**Consultation Response from KC,
Highways Development Management**

2024/91542 Centurion House, Centurion Way, Cleckheaton, BD19 3QB

Discharge condition 16 (parking) on previous permission 2022/92271 for demolition of Centurion House, erection of petrol filling station and ancillary unit with drive-thru and associated works

Date Responded: 24-7-2024.

Client	EURO GARAGES
Project	CLECKHEATON SERVICES
Title	SECTION 278 LINING WORKS
Drawing No.	WL_2390_002
Revision	P2
Scale	AS INDICATED
Date	03.11.23
Drawn	S.A.S.
Chk	E.Z.
App	G.E.
Unit 2.1, 20 Dale Street, Manchester, M1 1EZ	
Tel. 0161 236 8203

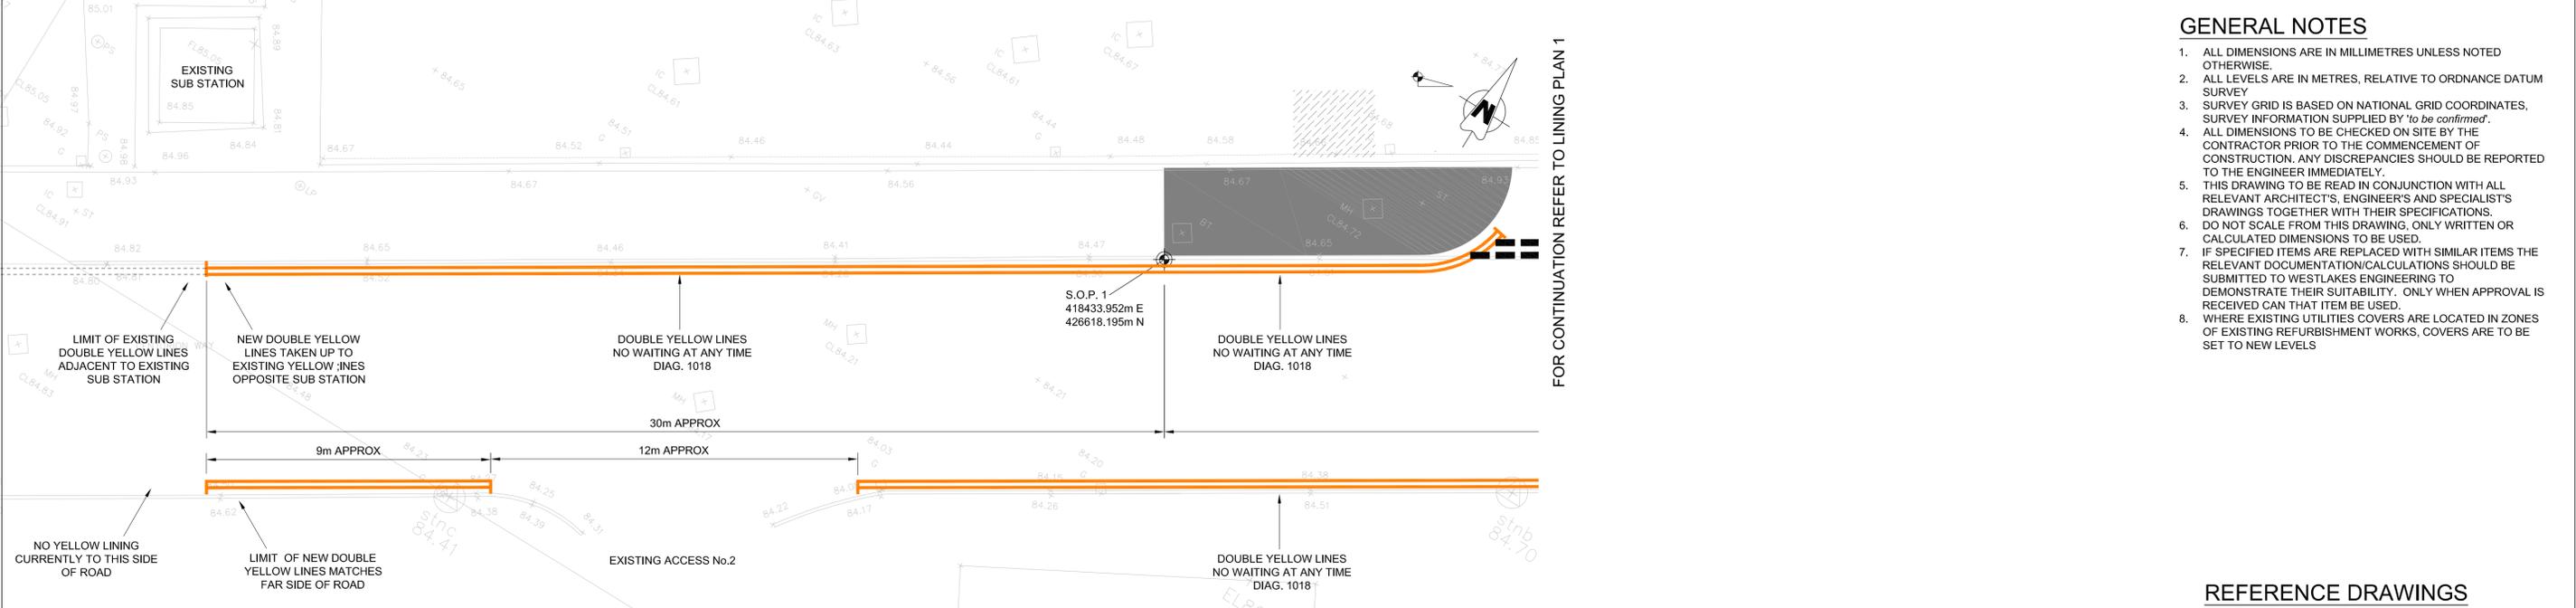
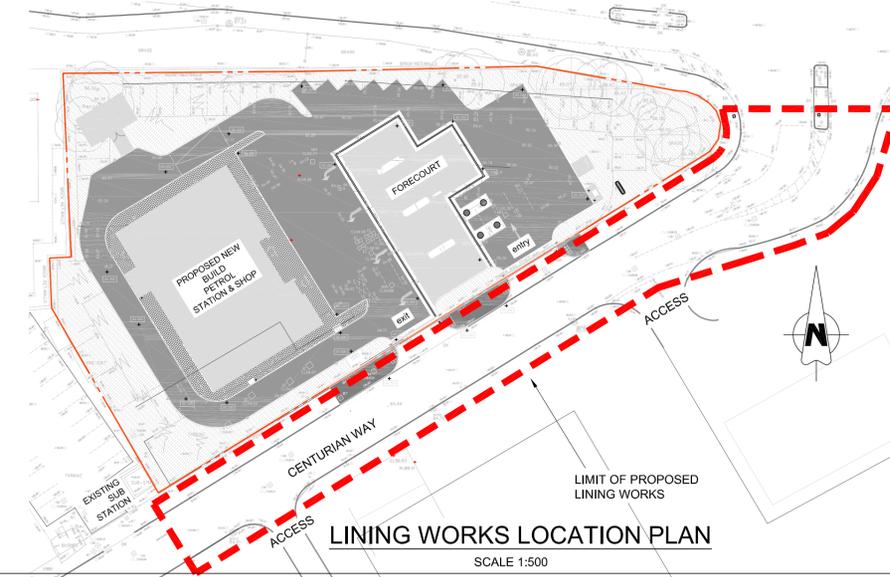
The applicants have provided plan number WL-2390-002 P2 Lining works showing waiting restrictions on both sides of the road from the traffic lights to the extent of the proposed development.

Highway Safety advise that the developer is in contact with our Highway Design section regarding implementation of the works and that the TRO has been advertised.

The first part of this condition can therefore be discharged.
